# CITY OF ALBUQUERQUE

March 17, 2022

**Re: Eagle Rock Commons, Building E**  
**5501 Eagle Rock Ave. NE**  
**30-Day Temporary Certificate of Occupancy**  
**Transportation Development Final Inspection**  
Engineer's Stamp dated 9-23-09 (C18-D037H)  
Certification dated 3-11-22

sheet no:
 S-1.0

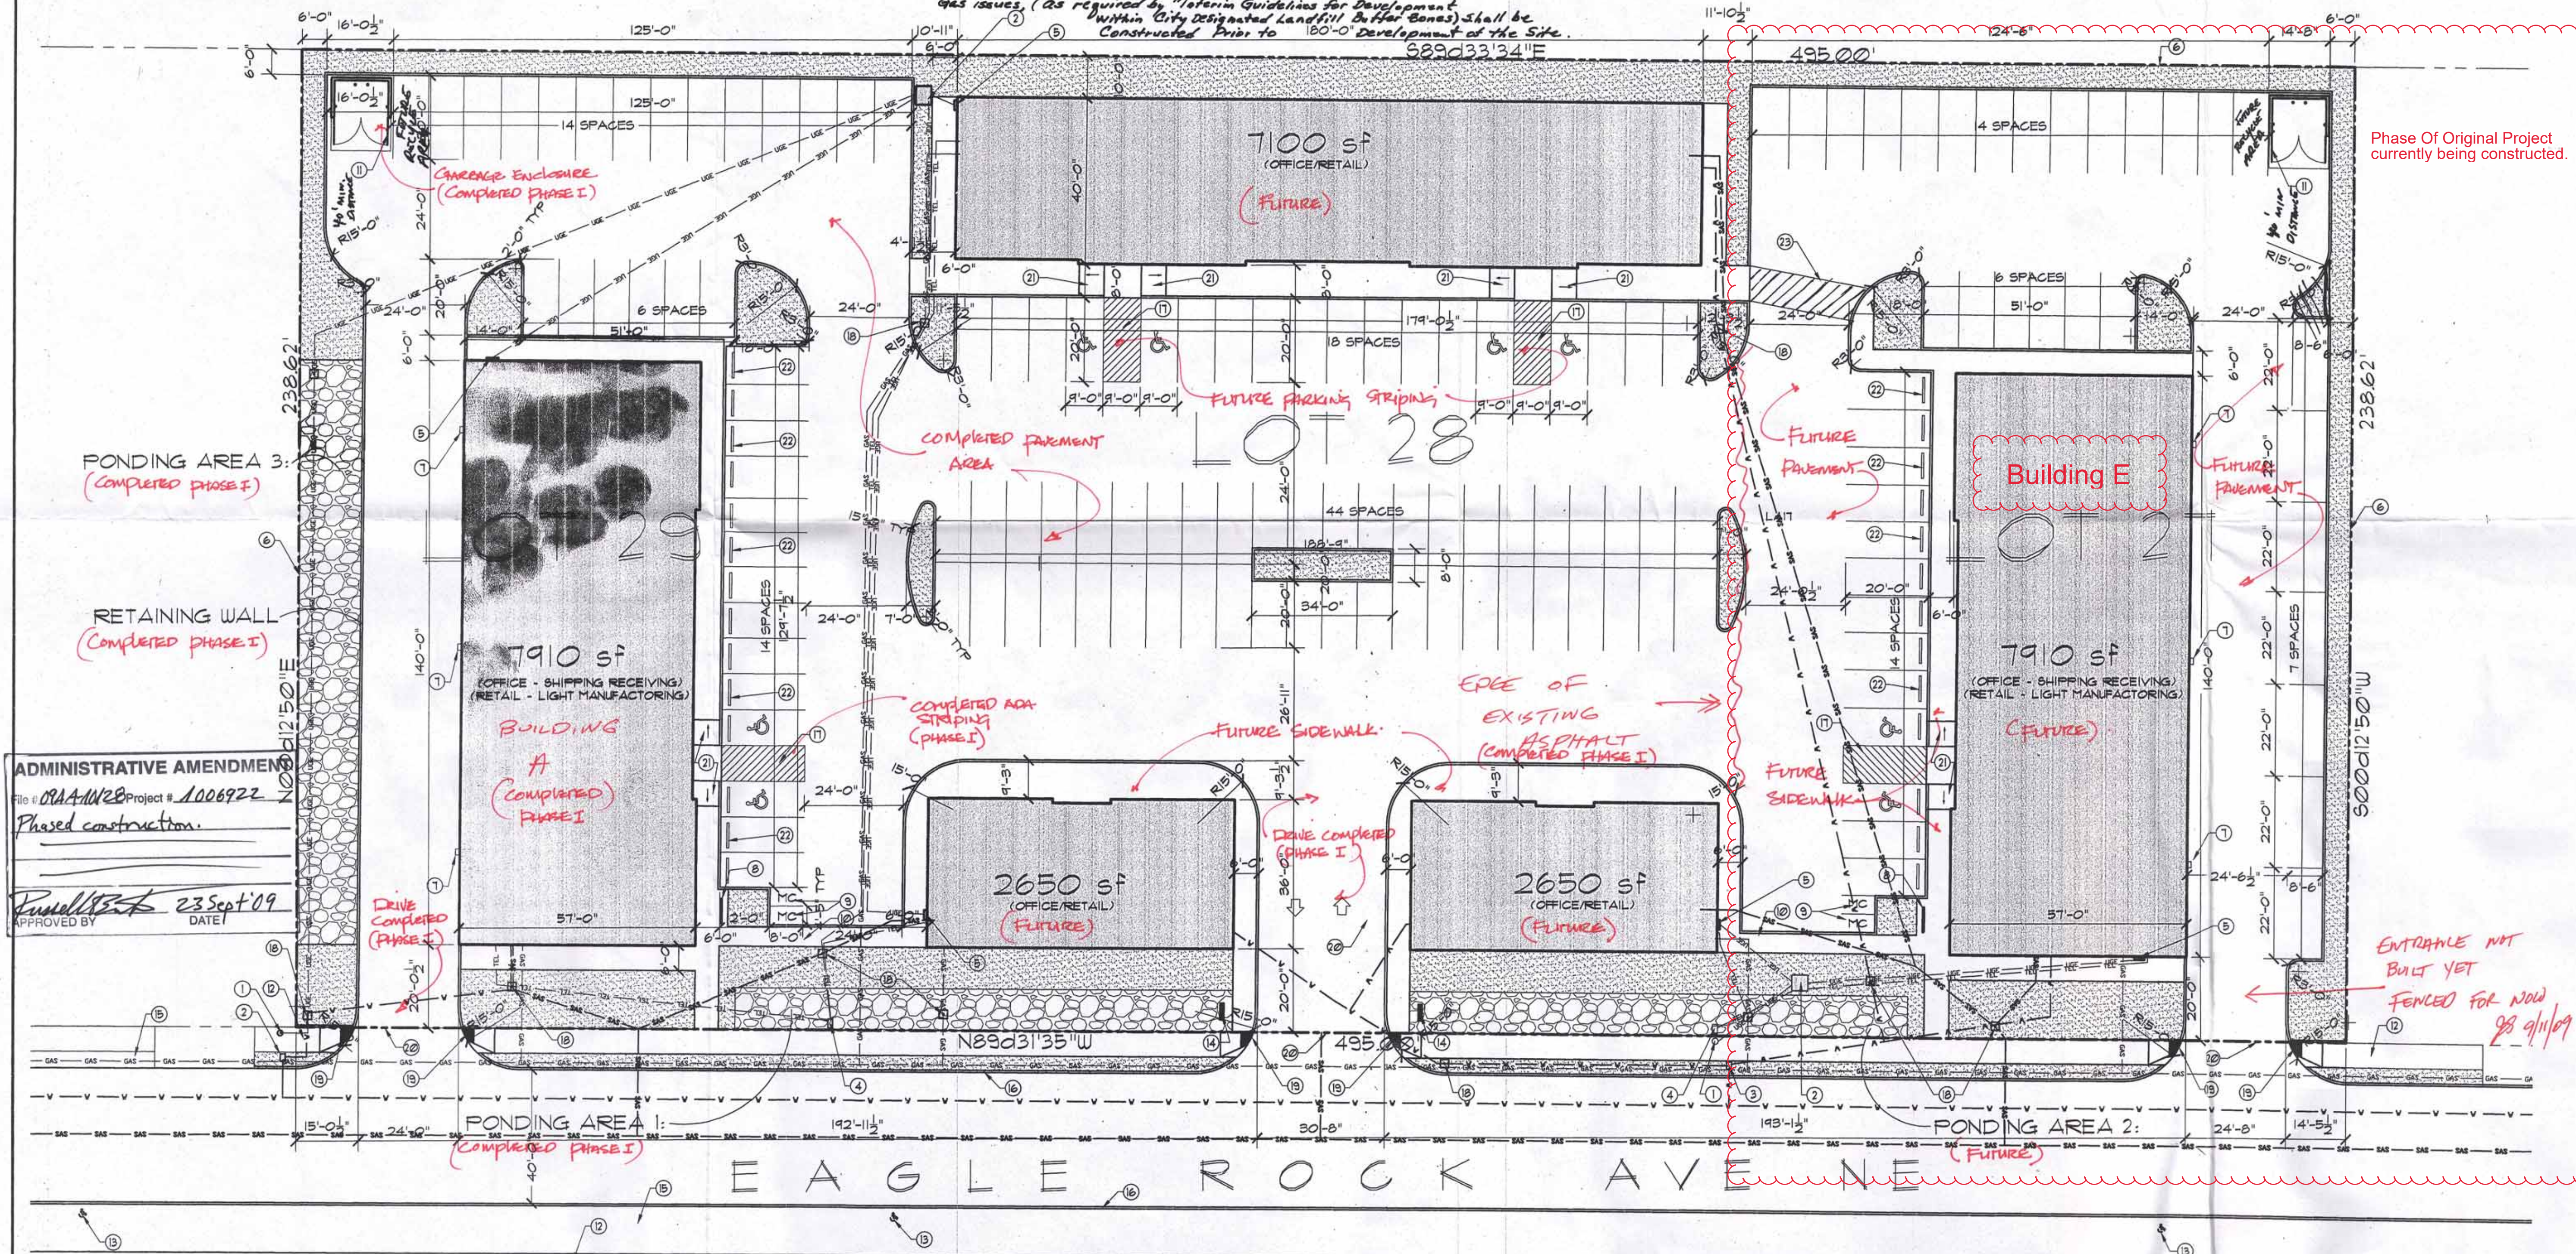
- Provide ADA parking signs.
- The ADA accessible parking sign must have the required language per 66-7-352.4C NMSA 1978 **"Violators Are Subject to a Fine and/or Towing."** Please call out detail and location of signs.
- The ADA access aisles shall have the words **"NO PARKING"** in capital letters, each of which shall be at least one foot high and at least two inches wide, placed at the rear of the parking space so as to be close to where an adjacent vehicle's rear tire would be placed. (66-1-4.1.B NMSA 1978)
- Motorcycle parking spaces shall be designated by its own conspicuously posted upright sign, either free-standing or wall mounted per the zoning code. And provide "MC" pavement marking for each space.
